Town & Country Planning Act 1990 (as amended)
Town and Country Planning (Development Management Procedure) (England) Order 2015
Approval of details reserved by condition imposed under LU/249/17/PL relating to conditions 3-
Construction Management Plan, 5-visibility splays, 15-landscape scheme & 16-schedule of materials
& finishes.
Directors Cottage Toddington Lane, Littlehampton,

Arun District Council have decided to **REFUSE details reserved by condition for the following reasons:**

Drawing: **SITE PLAN**

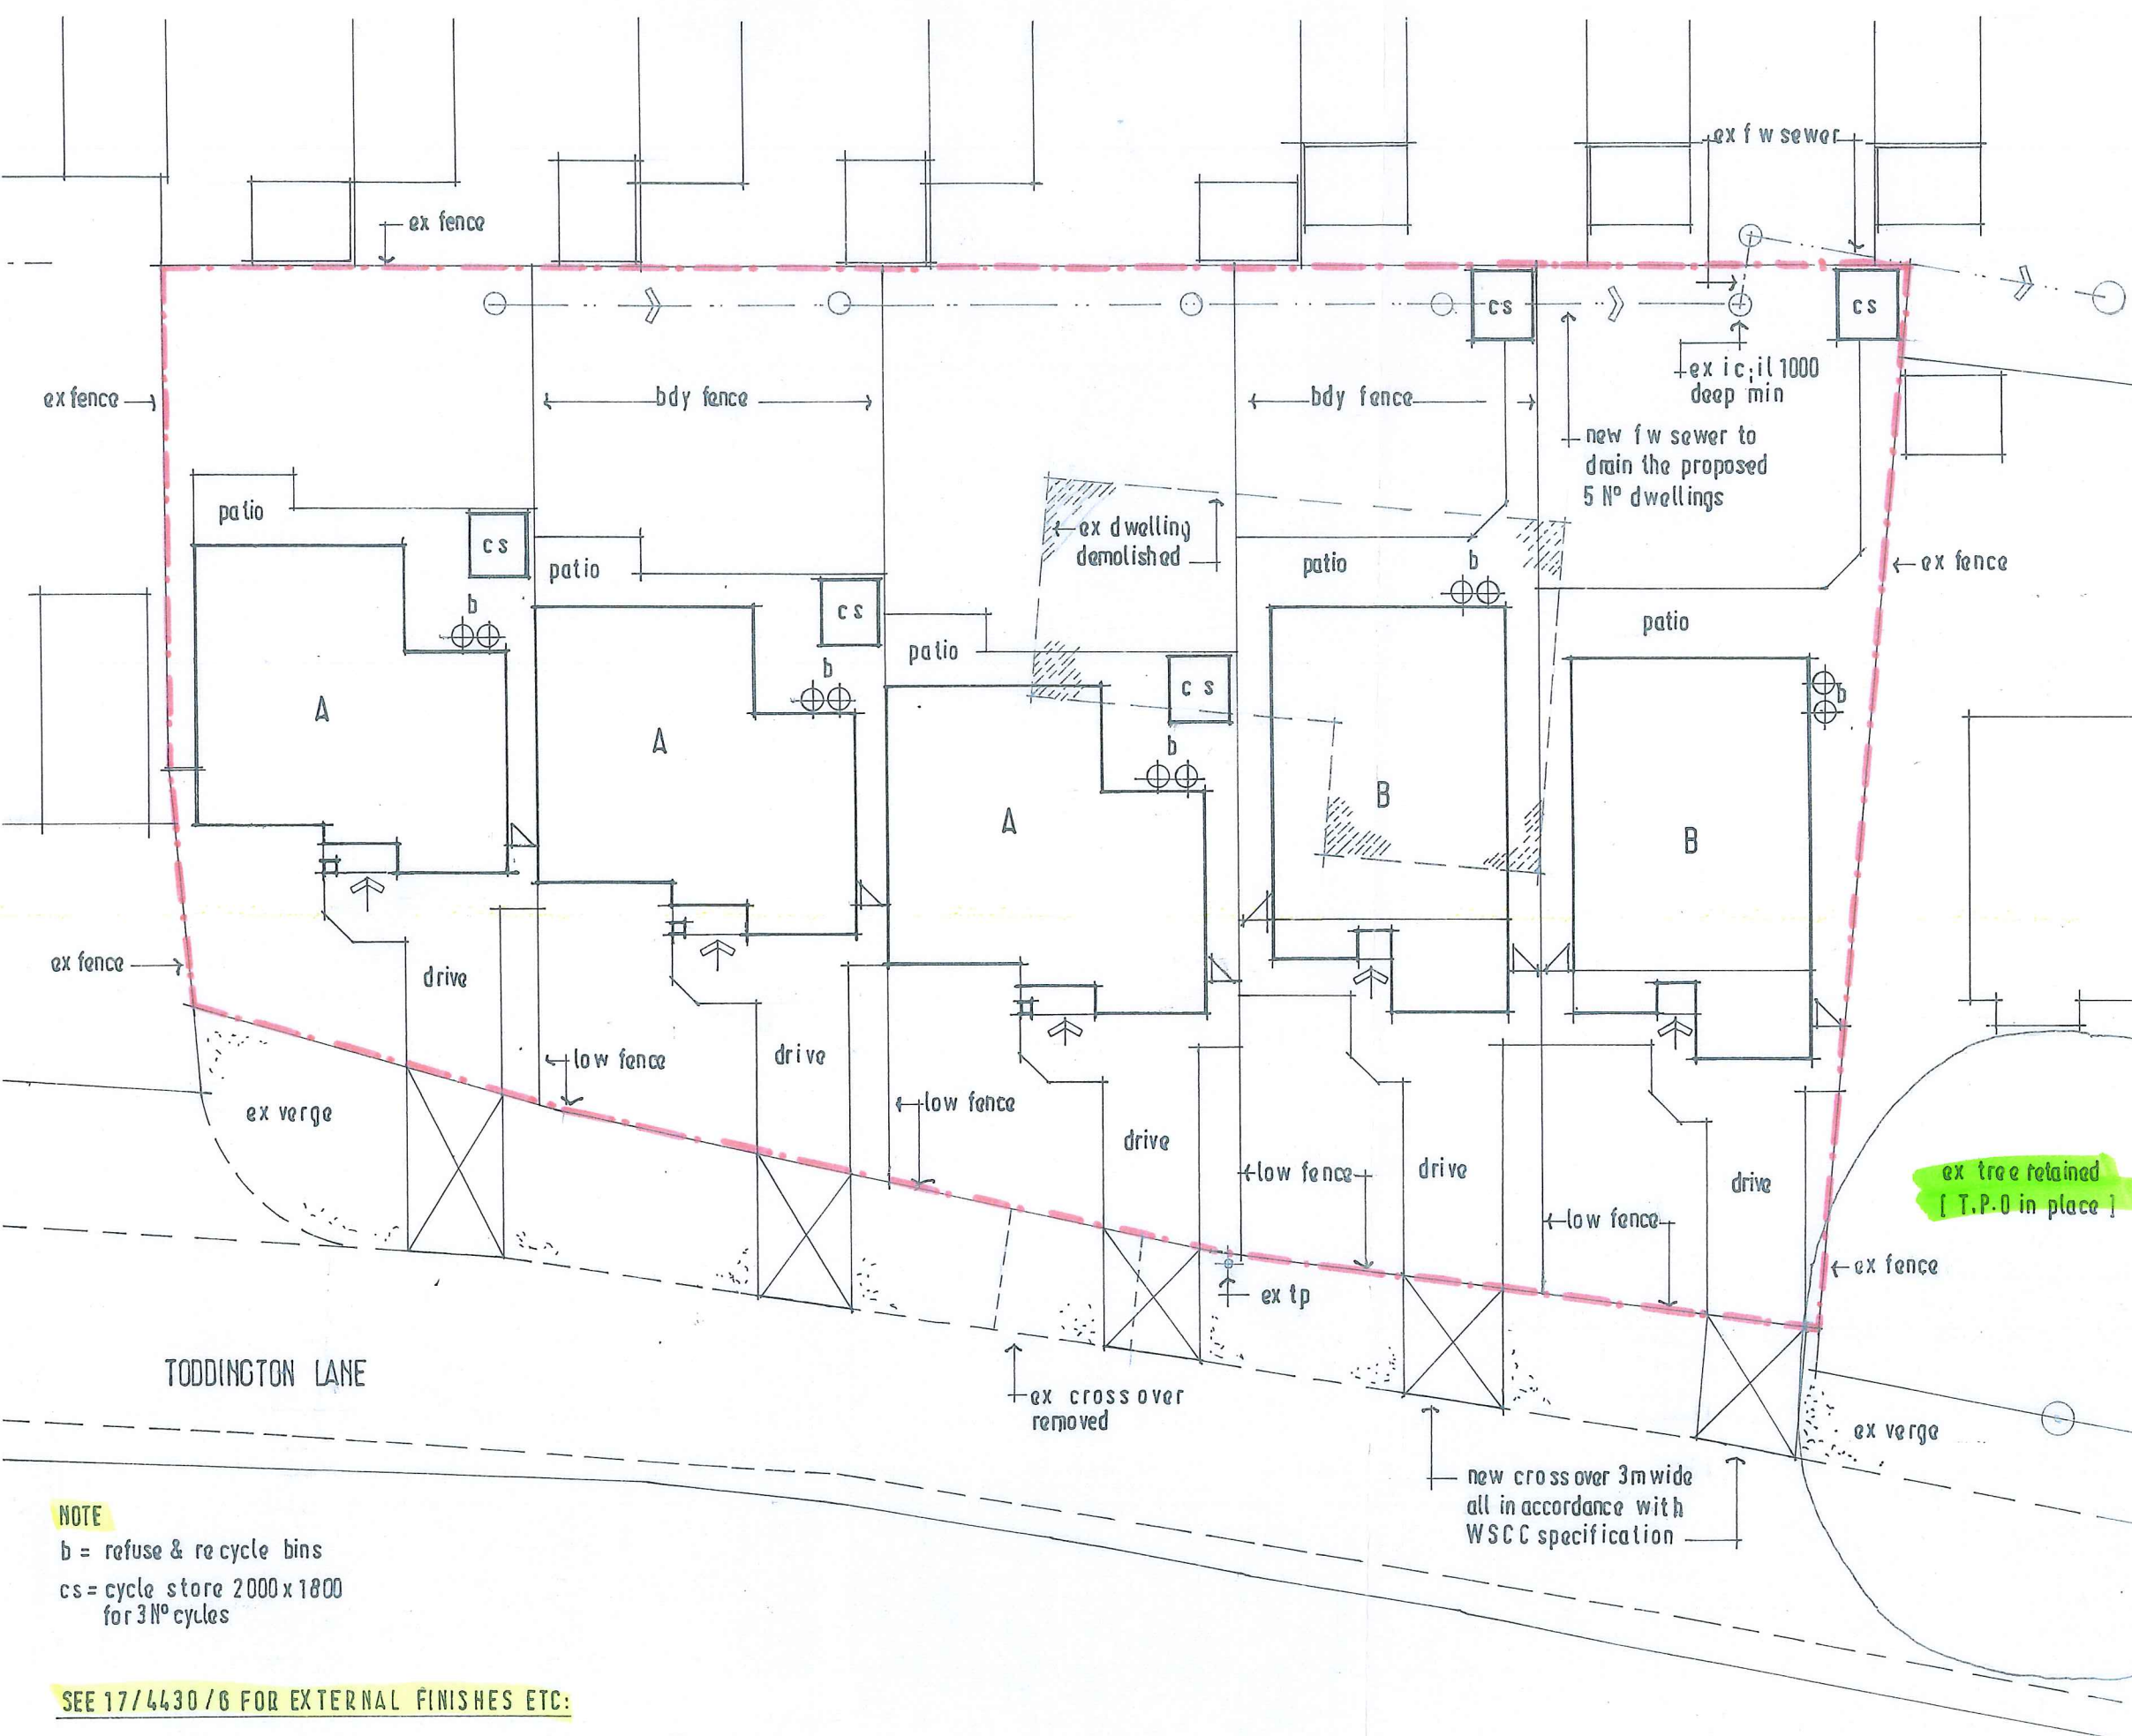
This condition cannot be discharged in sufficient information has been submitted. Details in plan form are required of proposed trees and shrubs detailing actual quantities, species choice planting density and size at time of planting
